KIRKLEES METROPOLITAN COUNCIL INVESTMENT & REGENERATION SERVICE

DELEGATED DECISION TO DETERMINE PLANNING APPLICATIONS TO CARRY OUT DEVELOPMENT WITHOUT COMPLIANCE WITH PLANNING CONDITIONS PREVIOUSLY ATTACHED

Reference No:	2026/70/91503/W
Site Address:	5, Woodsome Drive, Fenay Bridge, Huddersfield, HD8 0JR
Description:	Variation of condition 2 (plans) of previous permission 2024/91084 for erection of single storey rear, two storey side and two storey front extensions
Recommending Officer:	Laura Yeadon

Officer Report

Plans - As Proposed

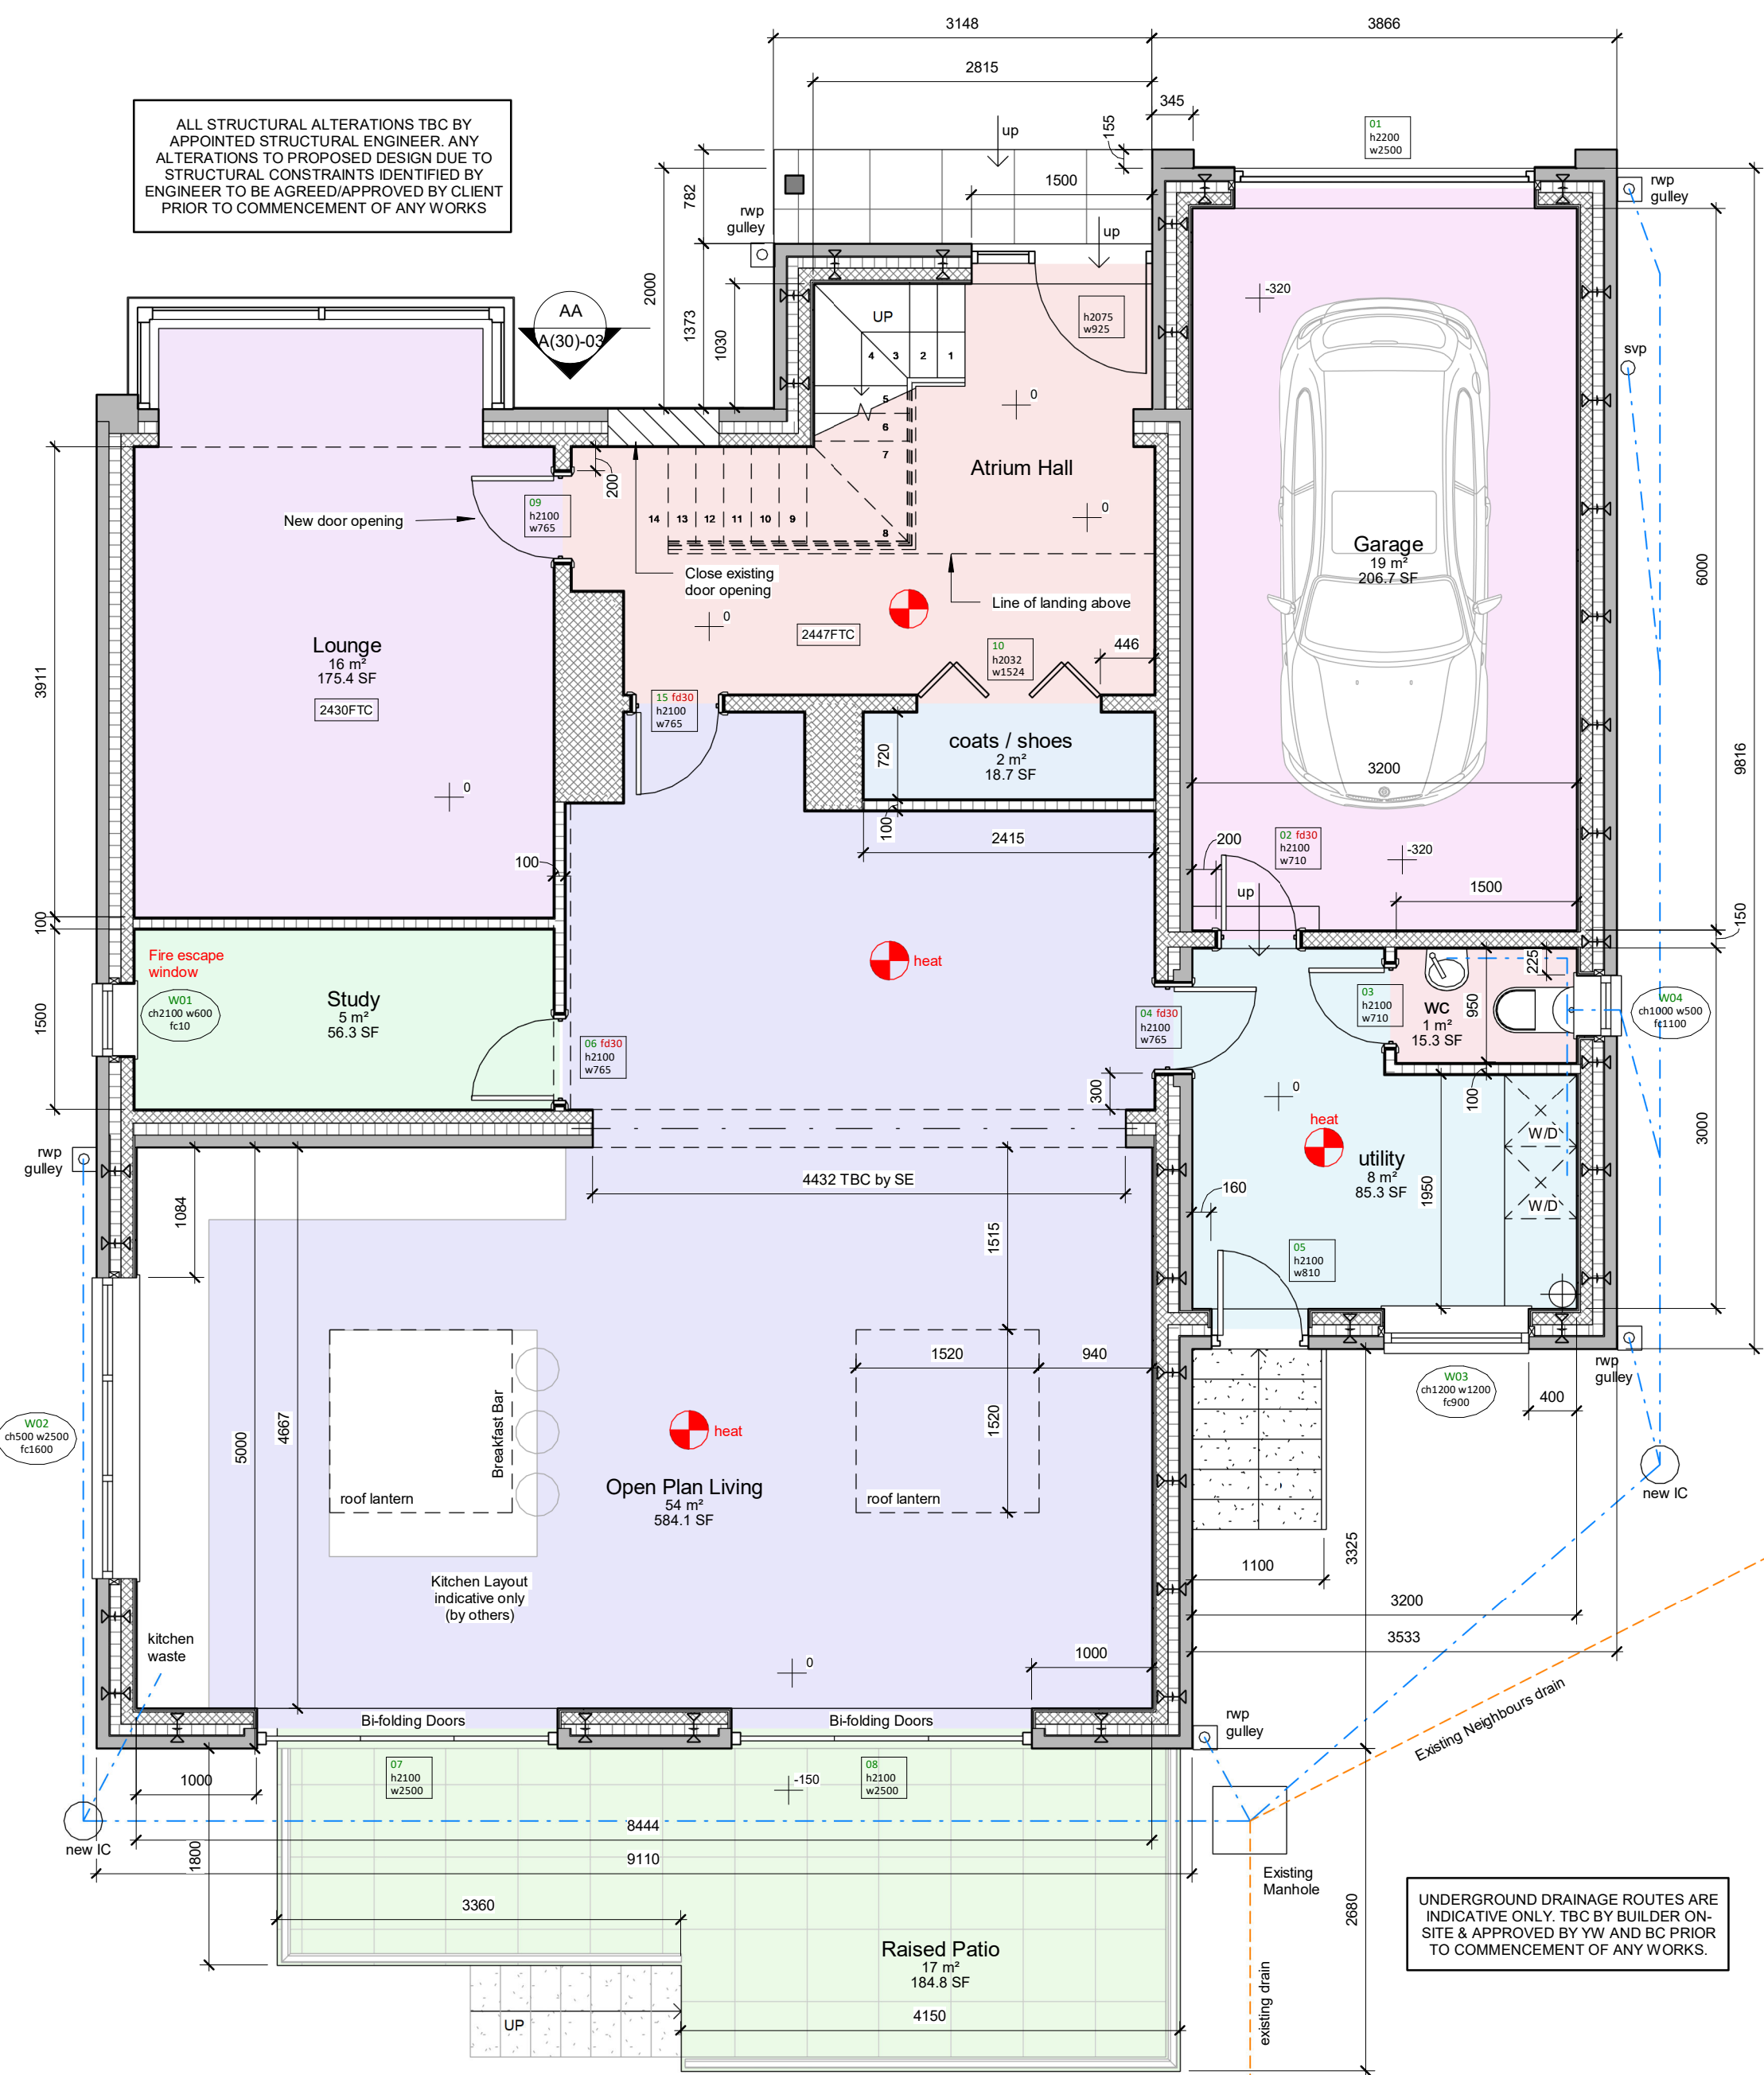
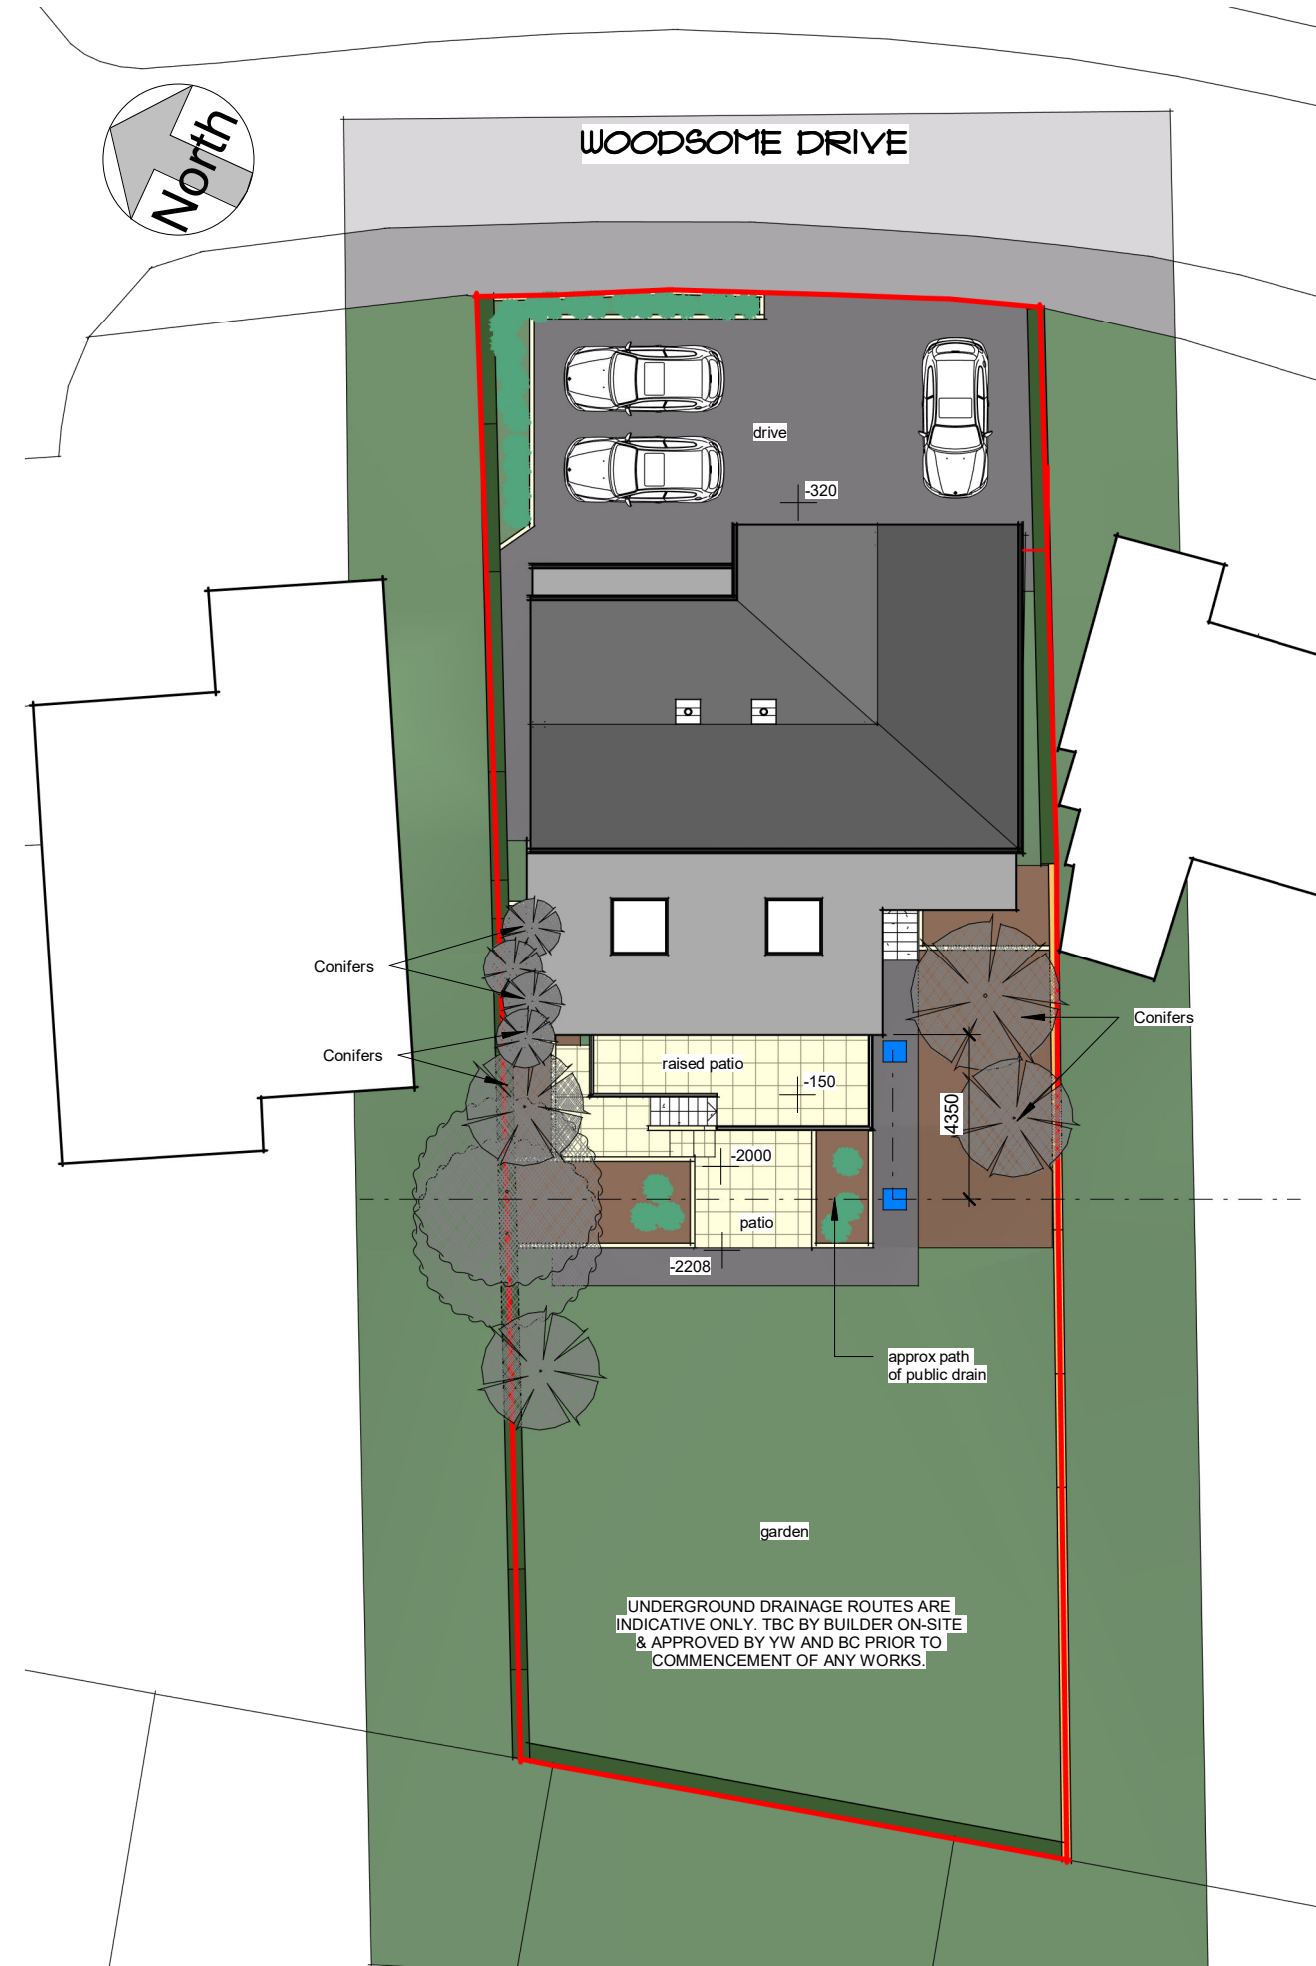
The approved plans demonstrate that the rear extension was set in from the side elevation of the property whereby the proposed plans seek to extend the width of the rear extension so that the side elevation would lie flush with the side elevation of the existing dwelling. There are no proposed alterations to the projection or height.

The amended internal layout does not require planning permission as the alterations in isolation would not materially affect the external appearance of the building.

It is proposed to insert a north facing ground floor side window to serve the study. The submitted plans indicate it will be obscure glazed.
